From: [Rodriguez, Jason T.](#)
To: [Harmon Rita T.](#)
Cc: ["Eric Tidmore"](#)
Subject: RE: 7500 Holly NE
Date: Wednesday, September 03, 2014 8:18:06 AM

At the request of Eric Tidmore of Trinity Construction I have performed a site visit at the 7500 Holly NE Dental Office project today to verify the construction progress and the general compliance of the site construction with our approved Grading and Drainage Plan permitted for this project. The COA Hydrology approval letter was dated December 9, 2013 on our plan that was stamped on 11/26/2013.

## GRADING AND DRAINAGE PLAN

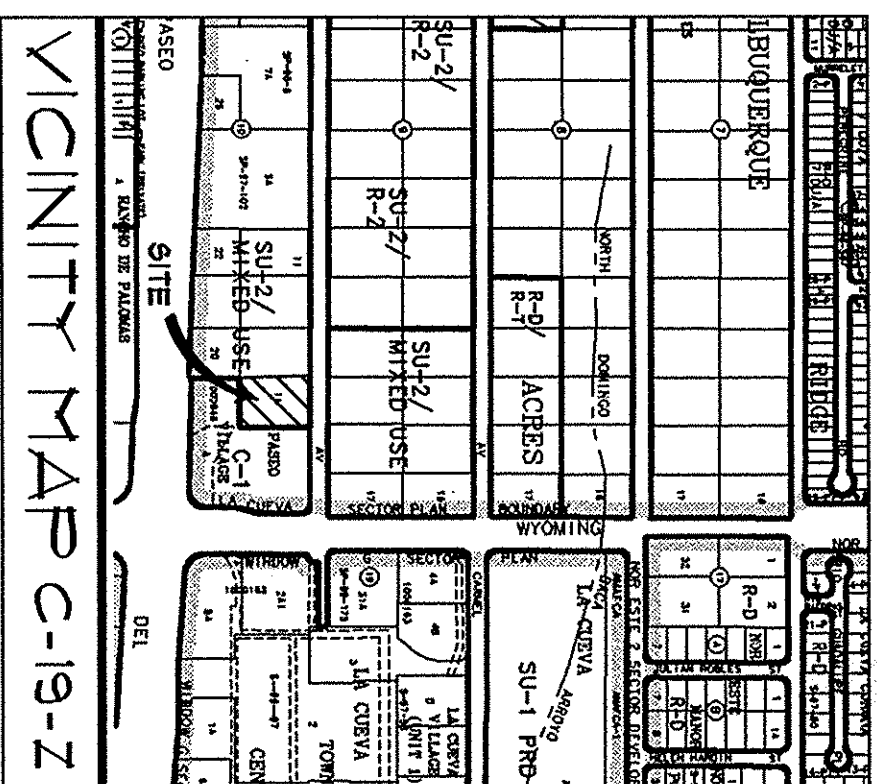
I was under the impression the existing drainage is fine to leave as is but we need to add the permanent galvanized plate to the side walk section and we need to add an additional diamond plate cover to the section that runs from the side walk to the street. Can you please

- Installation of permanent sidewalk culvert covers on site (2 each) and in the public R.O.W. on Holly Ave. (1 each). Apparently, the galvanized diamond plate that will be the final covers for these 3 structures has not yet been delivered by the supplier and so temporary covers have been installed. The temp covers do not extend the entire required length and have not been properly anchored but once the correct covers arrive they will be installed.
- Slope protective landscaping rock has not been completely installed on the north and west side of the site.
- An as-built topographic survey of the site has not been completed yet.

Good morning Rita I just talked with Eric and asked him if he could saw cut both sides of the culvert at the sidewalk and put some expansion material in he said he could. That would be the only thing need to complete the culvert. I will send an E-Mail when the culvert is complete
Thanks Jason C.O.A.

Your understanding of the north culvert condition is correct. I will indicate the smaller width on my Engineer's Certification once you get me the as-built survey.
